DEVELOPMENT REVIEW BOARD

Parks and Recreation Department

PR-2021-005573

REQUEST: AN APPROXIMATELY 117.53 ACRE EXPANSION OF THE EXSITING ALBUQUERQUE STUDIOS CAMPUS INCLUDING A NEW PRODUCITON OFFICE, MILL BUILDING AND PRODUCTION SUPPORT SPACES.

**ALTERNATIVE
LANDSCAPE PLAN**

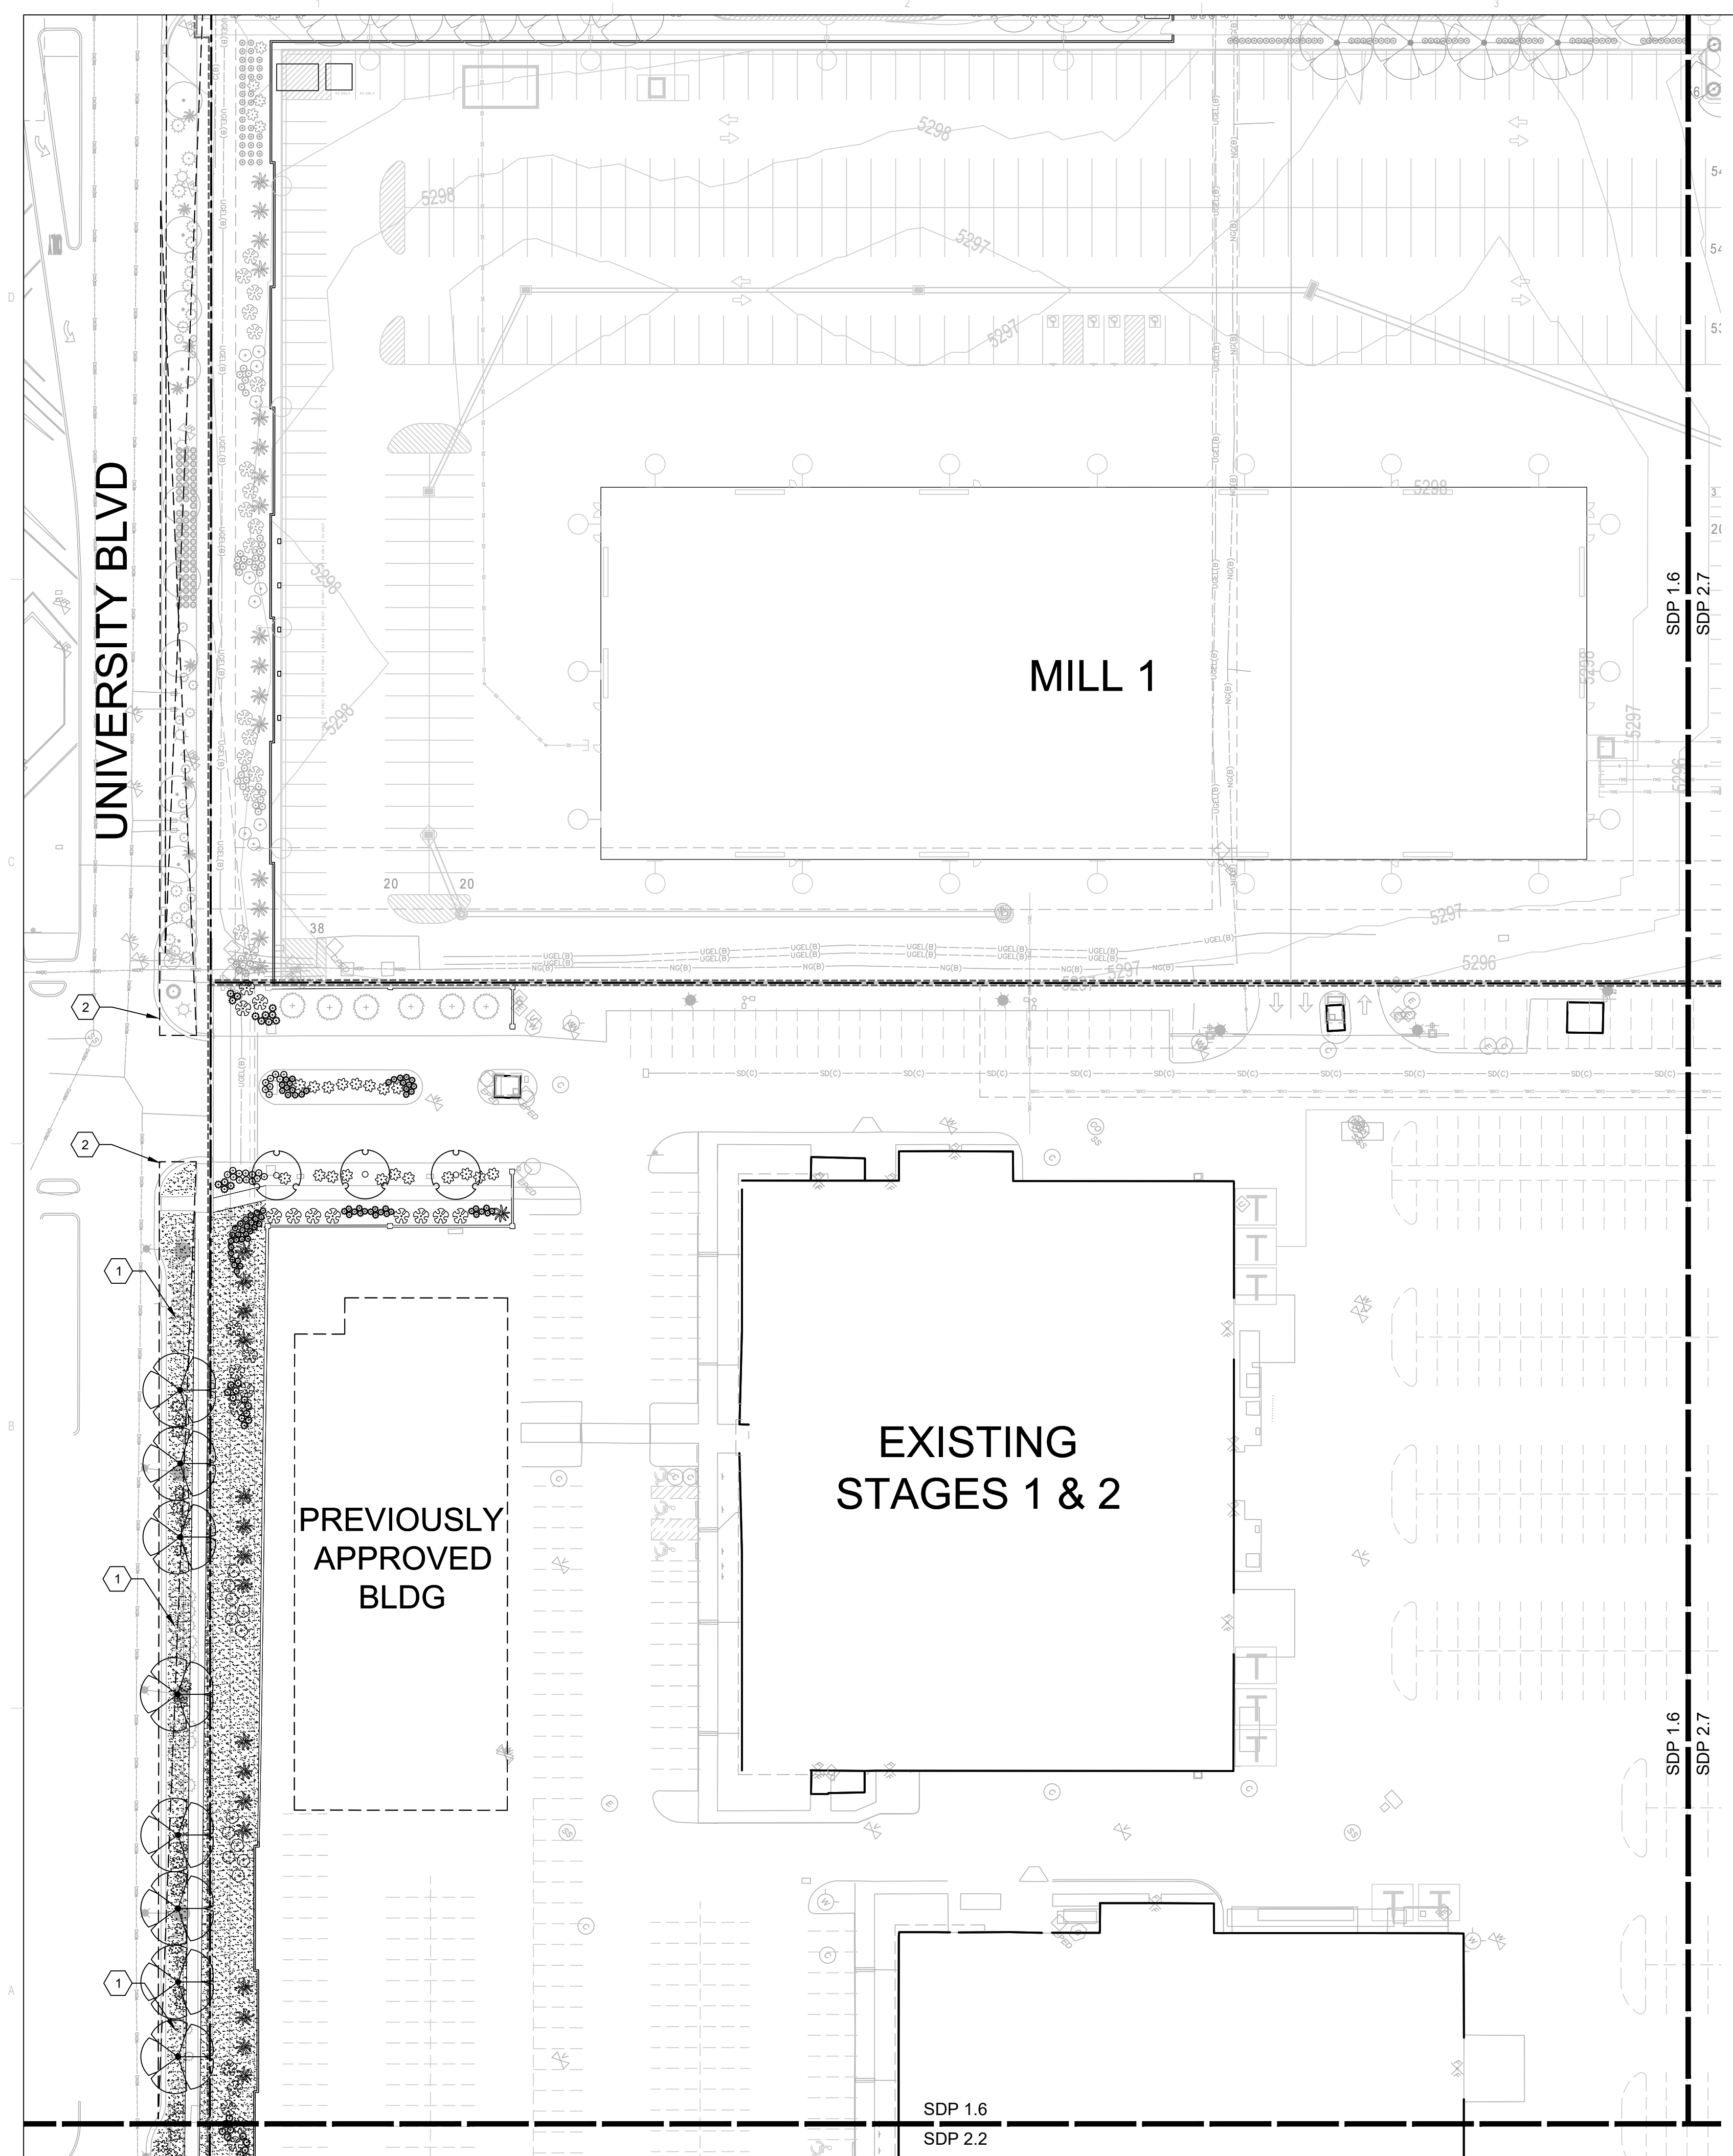
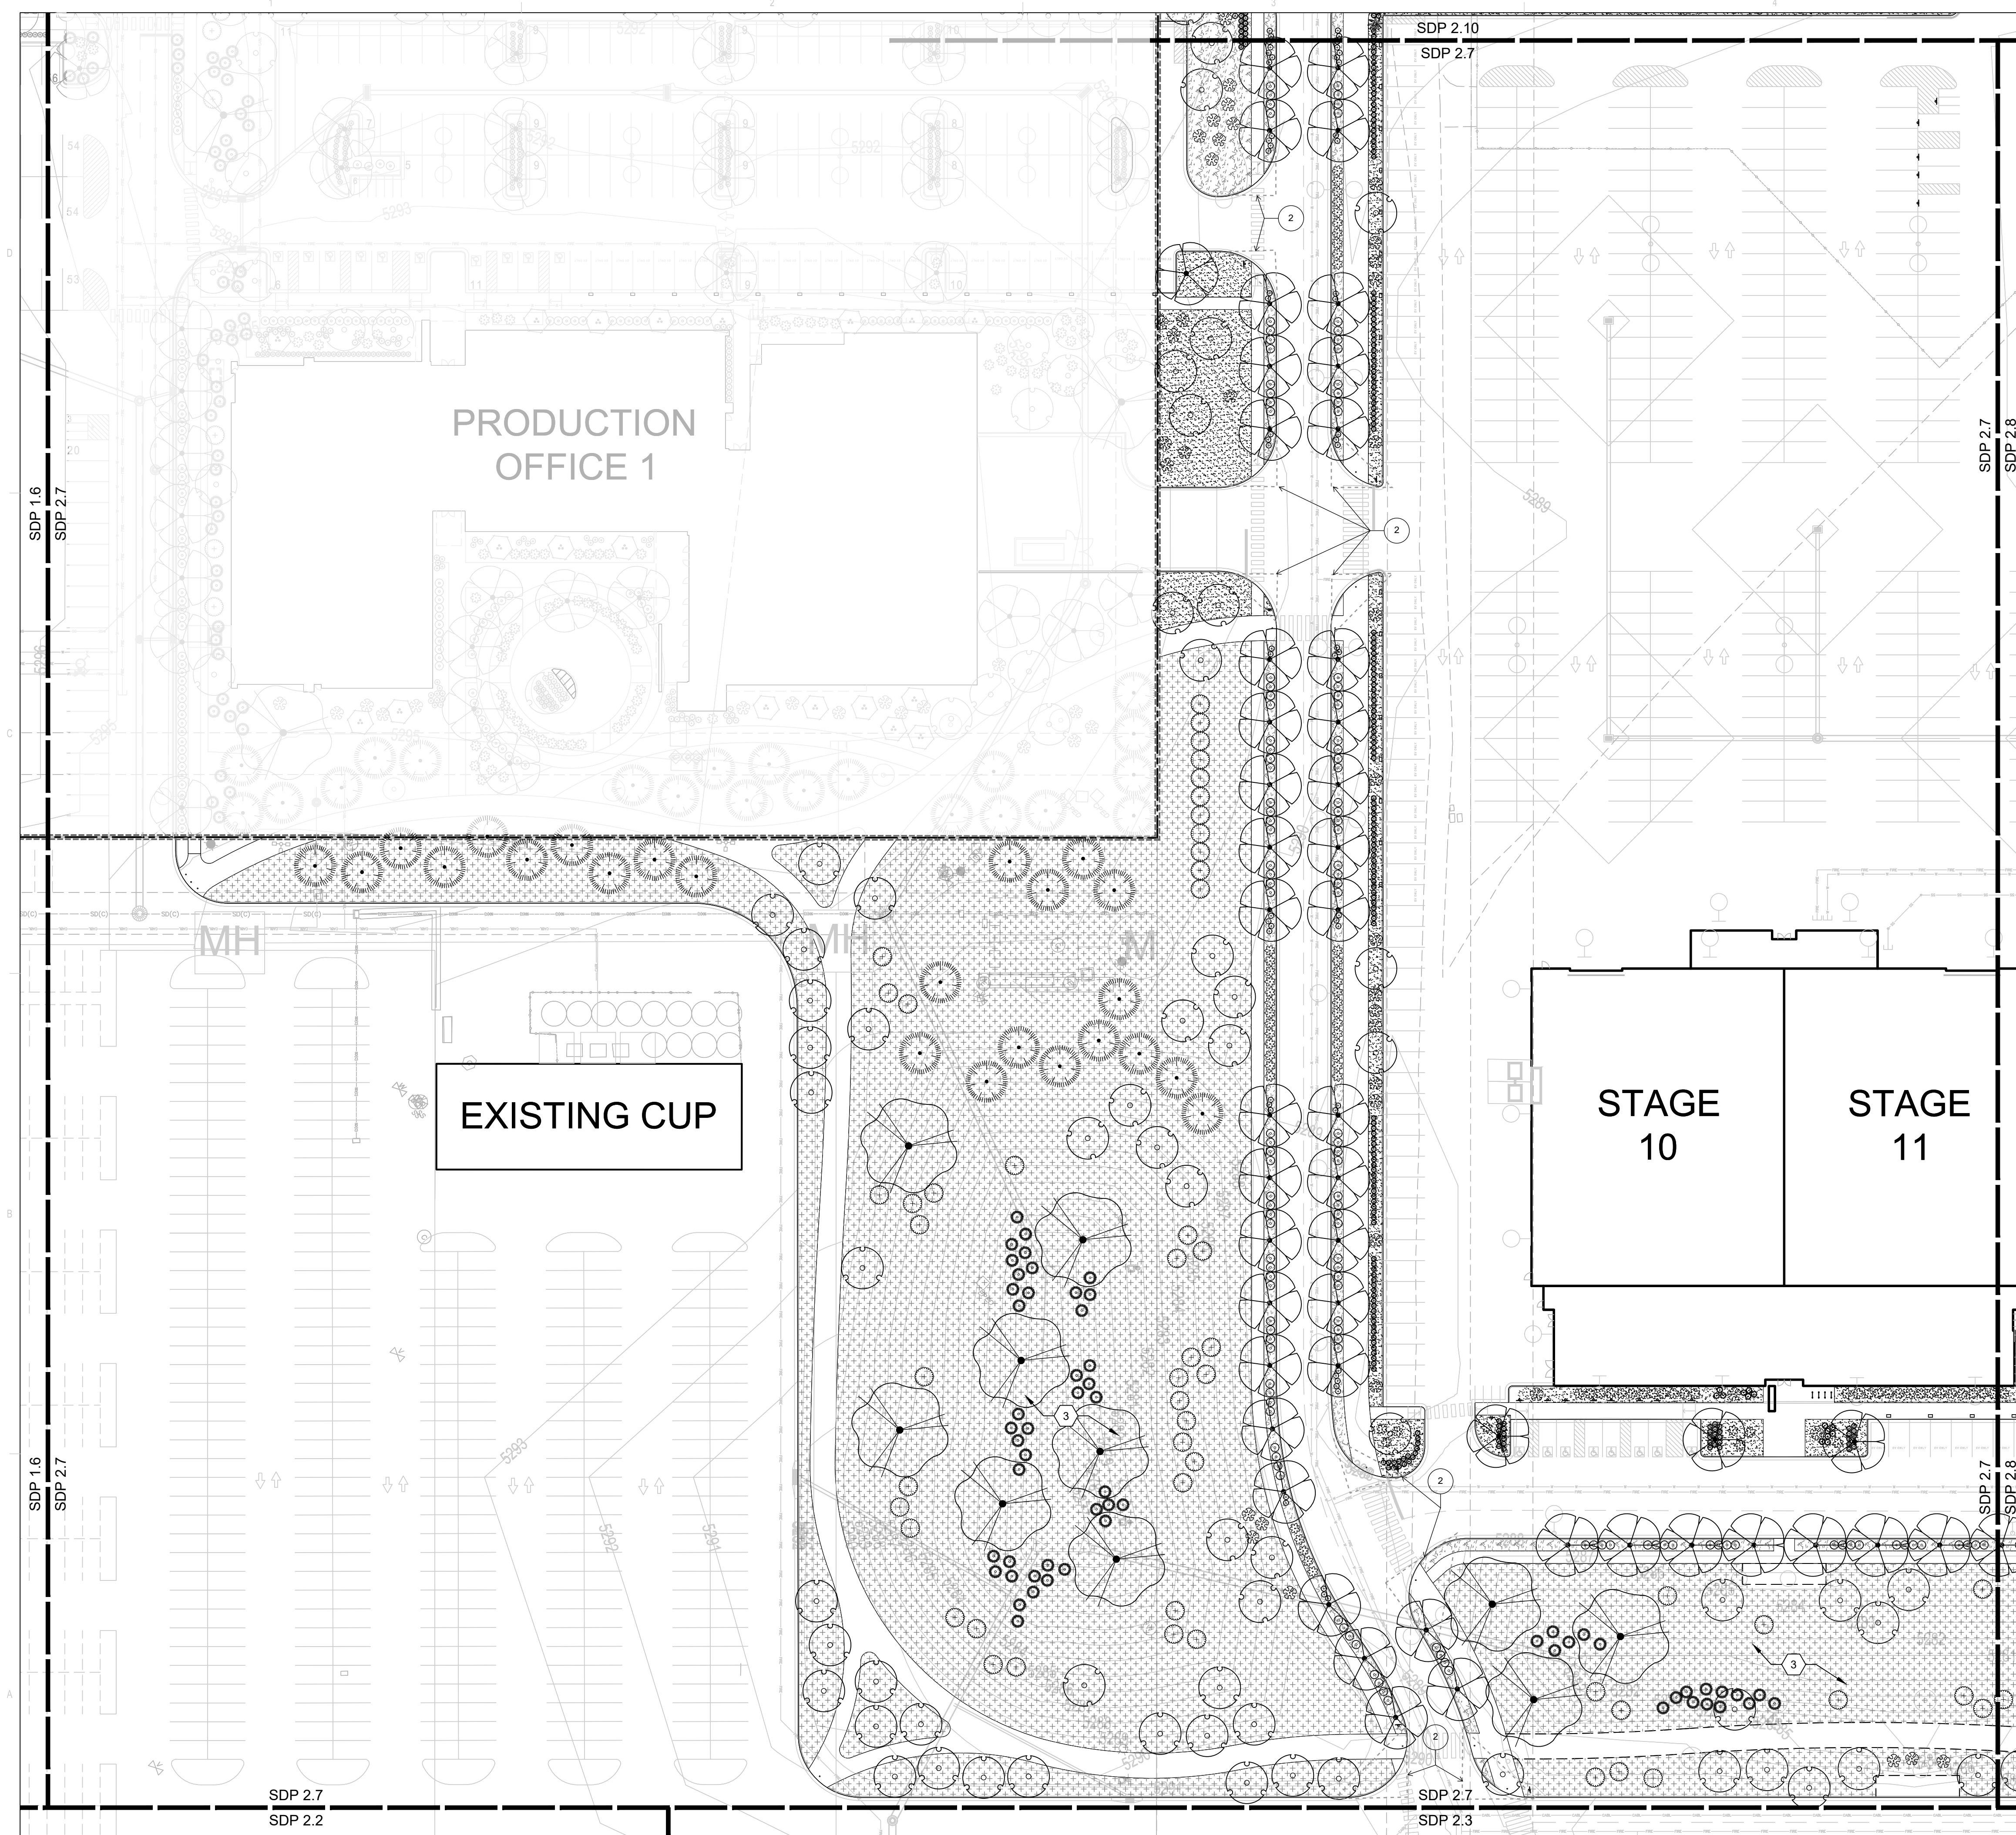
Is the plant pallet derived from a Mesa del Sol list? – if so, please provide referenced master list and/or page along with list for native seed mix. Where rock mulch used, please provide note regarding wood mulch for trees per 5-6(C)(5)(e).
